Recommendation Report for Planning Permission for Works or Extension to a Dwelling

REF NO: EP/48/21/HH

LOCATION: 2 Bay Tree Garden
East Preston
BN16 1JG

PROPOSAL: Erection of single storey rear extension and rear dormer following the demolition of existing garage and workshop.

Proposed Materials:
Roof Tiles - Black tiles t.b.c
Walls - Thermowood charred timber cladding and painted render
Dormer Walls - Thermowood charred timber cladding

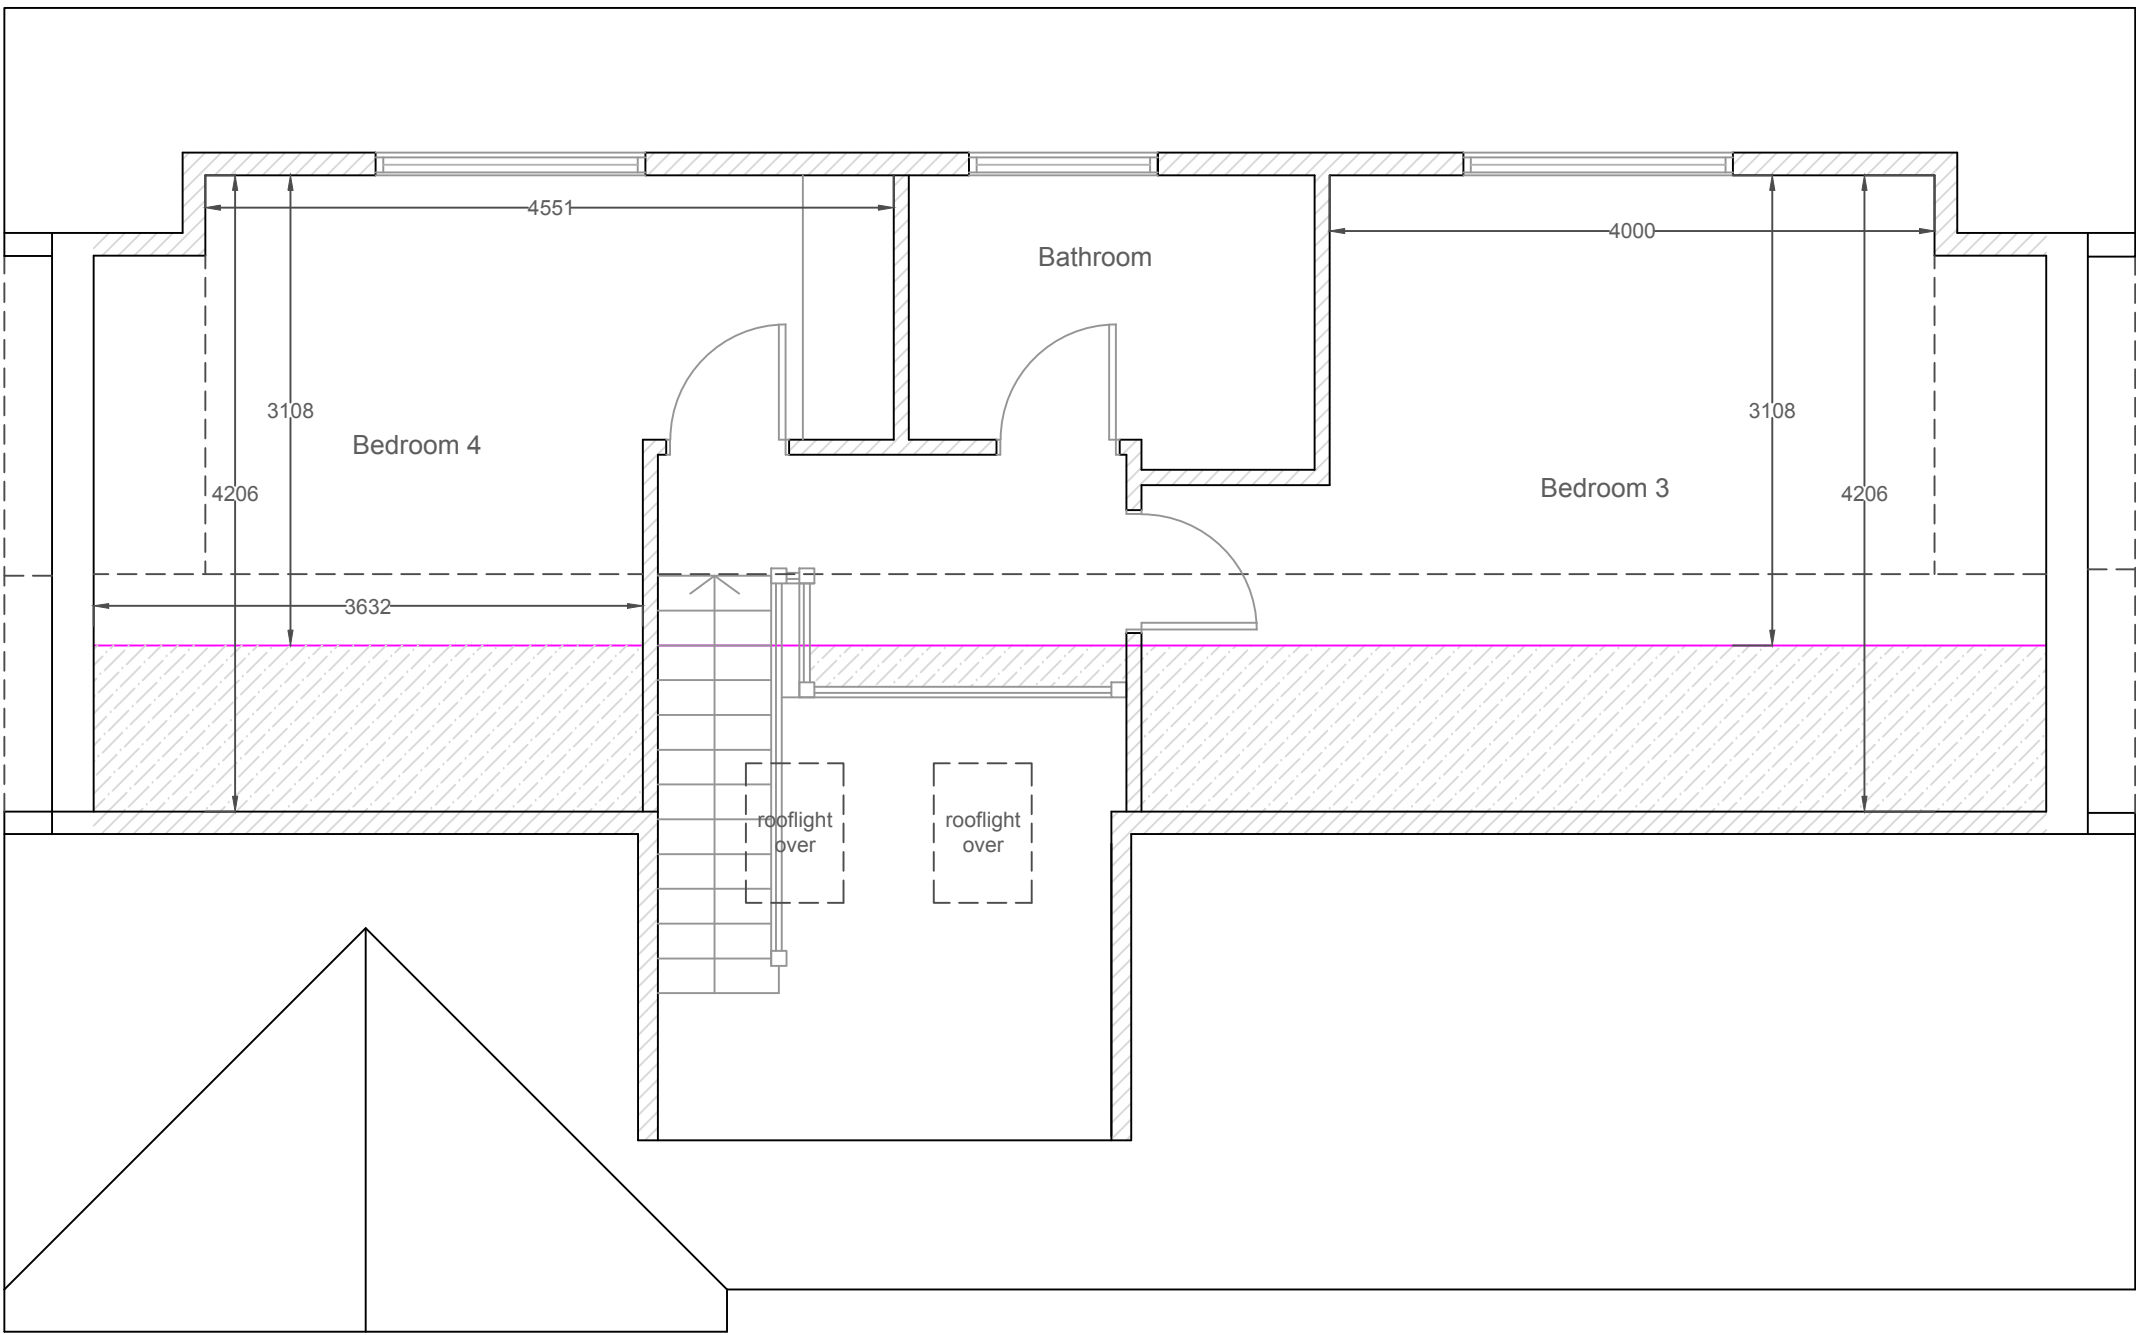
The rear dormers could be built under the provisions of permitted development. The two rooflights in the front elevation are set within the roof profile. The dormer extension in terms of design and size conflicts with Arun's Design guide part M which favours small scale roof extensions. The total allowance on the roof extension with hip to gable extension is 50 cubic metres under PD regulations. However in this case applicant has not chosen to alter the roof from hip to gable and instead increasing ridge height marginally to add rear dormers.

The single storey extension would be sited adjacent to the boundary with the adjoining property. The

layout of the extension contradicts Part M of the Arun Design Guide in terms of size, scale and position. The proposed extension is only being permitted based on the existing outbuildings which is in situ adjacent to the boundary and next to the host dwelling. The footprint of the extension would match the existing outbuilding; however the height on the northern boundary appears to be slightly higher than the outbuilding. The height is not significantly higher to warrant refusal. It is noted that adjoining property also contain extension within the residential curtilage. Therefore, no significant harm to residential amenity would be caused in terms of loss of light, loss of outlook, loss of privacy or any overbearing impact.

The application site does not benefit from the lengthy garden and it is approximately 7.8m in depth. There are residential properties sited at the rear of the application site and due to the orientation of these dwelling, the dormer windows would not afford direct views in the private habitable areas. The total height of the dwelling is approximately 5.5m high and the dormer window are set below the roof profile; therefore it is considered that the proposal would not cause significant overlooking which would be detrimental to living conditions of the nearby occupiers. The roof extension would encompass two rooflights in the front elevation, there would access to natural light to the bedrooms; therefore planning condition would be imposed for obscure glazing.

- 3 The dormer windows in the rear elevation of the dwelling for bathroom and two bedroom windows shall be glazed with obscured glass and non-opening above 1.7m.
